**KIRKLEES METROPOLITAN COUNCIL
INVESTMENT & REGENERATION SERVICE**

DELEGATED DECISION TO DETERMINE PLANNING APPLICATIONS

Reference No: 2017/62/94182/W

Description: Erection of single and two storey rear extension

Dwg No. - 8242/03

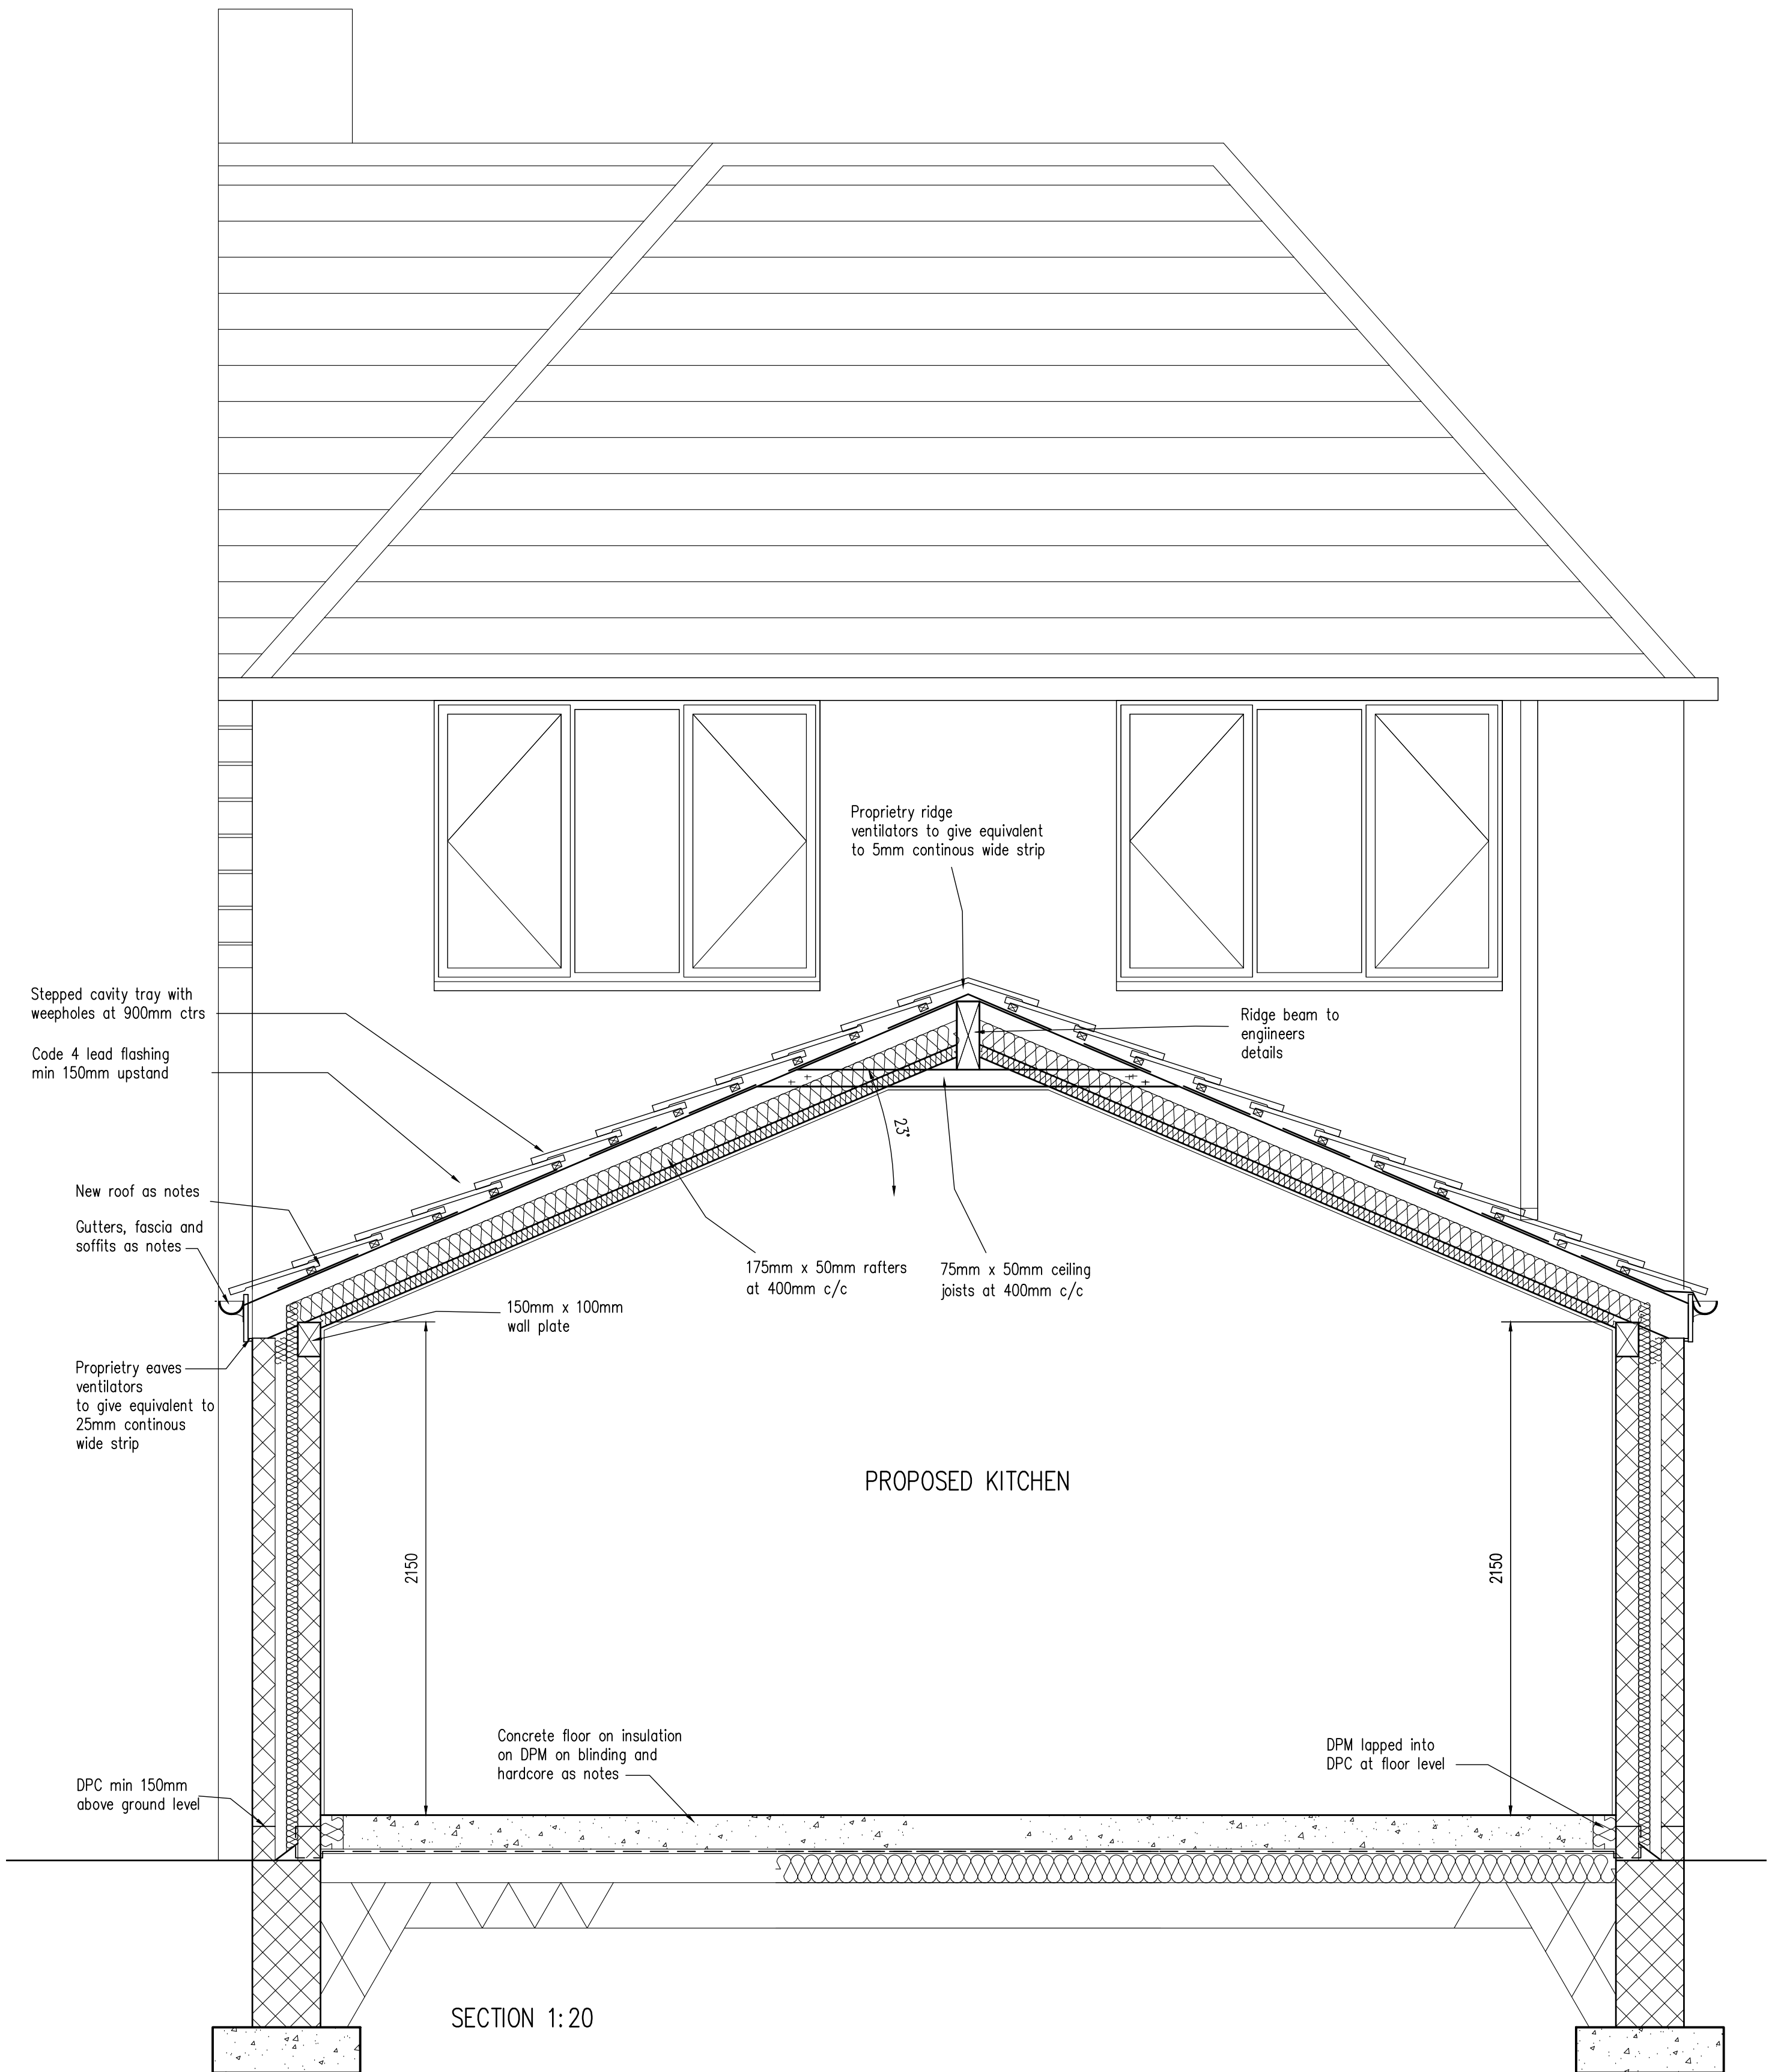
meet the adjoining property at a higher eaves level than the existing. The proposed new eaves height at the rear would be 5.20m, 1.25m higher than that of the adjoining property. This mismatch in heights would be negotiated by means of a vertical tiled perpendicular wall section.

The application house and adjoining semi-detached property were designed as a symmetrical pair of dwellings with a low eaves level and matching dormer openings in the front and rear roof planes. From the front and rear elevations, the property appears to be one-and-a-half storeys in height. The current proposal does not respect the distinctive roof style, nor the symmetry and balance of the pair of dwellings. As such, the proposal is not considered compliant with UDP Policy BE13.

The proposed extension would not create a dwelling that would be overly large in scale, in comparison to others in the vicinity. However, it would make the application property disproportionately large in comparison to the adjoining semi-detached property. As existing, Numbers 156 and 158 Laund Road comprise a well-proportioned and balanced pair of semi-detached properties. To extend one of the properties to the scale proposed would change the overall form, design and character of the building to an inordinate degree and, as such, the proposal is not considered to be compliant with UDP Policy BE2 (criterion i).

1. The proposed two storey rear extension by reason of its height, depth and mass would change the overall form, design and character of the host property and the pair of semi-detached properties of which it is a part to an inordinate and unacceptable degree and would be detrimental to the visual amenity of both the application dwelling and the adjoining dwelling. Furthermore, the scale and mass of the proposal would be detrimental to the occupiers of 156 Laund Road by reason of overbearing. To permit such a development would be contrary to Policies D2 (v, vi, vii), BE2(i), BE13(iii, iv) and BE14 of the Kirklees Unitary Development Plan, Policy PLP24(b and c) of the Kirklees Publication Draft Local Plan and the core planning principles and policies in Chapter 7 of the National Planning Policy Framework.
